Consultee Comment for planning application 6/2019/2714/OUTLINE

Application Number	<input type="text" value="6/2019/2714/OUTLINE"/>
Location	<input type="text" value="1 YMCA 90 Peartree Lane Welwyn Garden City AL7 3UL"/>
Proposal	<input type="text" value="Outline planning application for a hybrid application for demolition of existing hostel,development of a four storey 100 bed YMCA Hostel(All details submitted for determination)and a 2,3 and 4 storey building providing up to 43 residential apartments (All details retained for future determination as reserved matters,except means of access)with associated car parking and landscaping"/>
Case Officer	<input type="text" value="Ms Clare Howe"/>
Organisation	<input type="text" value="WHBC - Client Services"/>
Name	<input type="text" value="Lorraine Davis"/>
Address	<input type="text" value="Client Services The Campus Welwyn Garden City AL8 6AE"/>
Type of Comment	<input type="text" value="Comment"/>
Type	<input type="text"/>

Title
PROPOSED
BLOCK PLANS

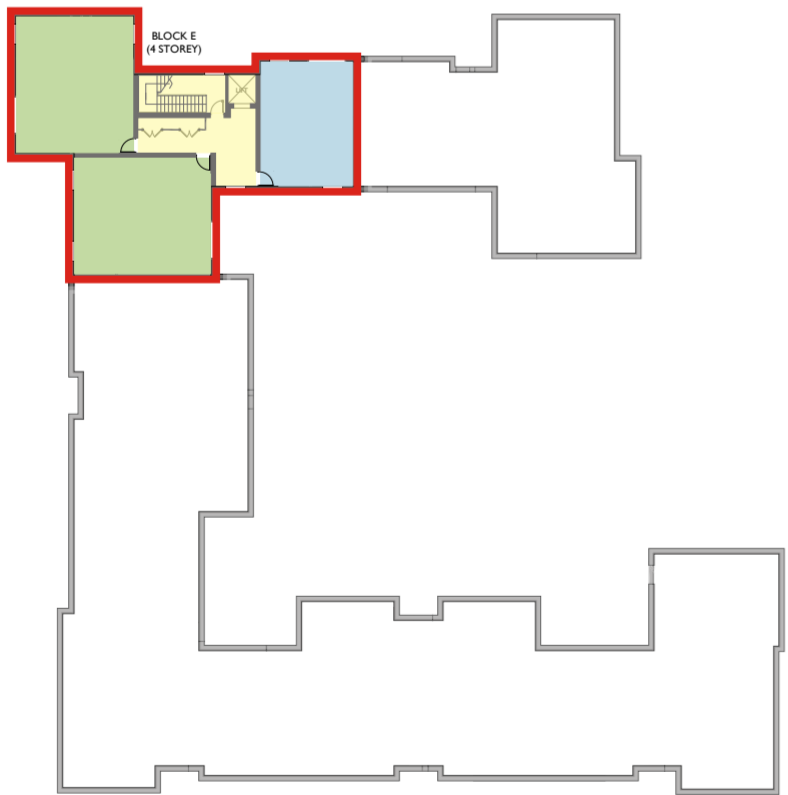
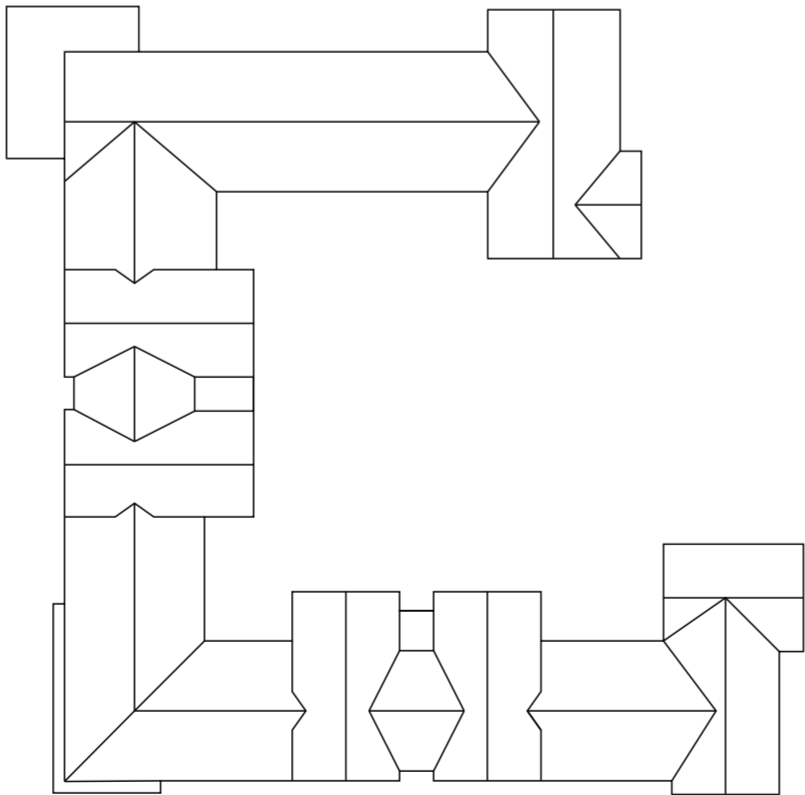
Comments	<input type="text" value="19/11/2019 - Lorraine Davis. The YMCA would need to source its own Trade Waste contract for Refuse/Recycling. They can approach the Councils contractor directly for a quote or utilise any other Trade provider they so wish. The residential units - I see 2 bin stores have been included in the design which is appropriate. Each bin store should have 3 x 1100l containers and 1 x Mini Recycling Centre (so total 6 x 1100l and 2 x MRC) I attach our Bin store guidance document and the BS Code of practice to which we work. NOTE: requirement include double doors opening outwards, coded door locks. maximum drag distance of 15m from store to freighter with minimum 2m wide flat smooth path and dropped kerb if necessary. 1100l cost ?390.00 each and MRC ?574.00 each"/>
Received Date	<input type="text" value="19/11/2019 13:40:24"/>
Attachments	<input type="text" value="The following files have been uploaded:
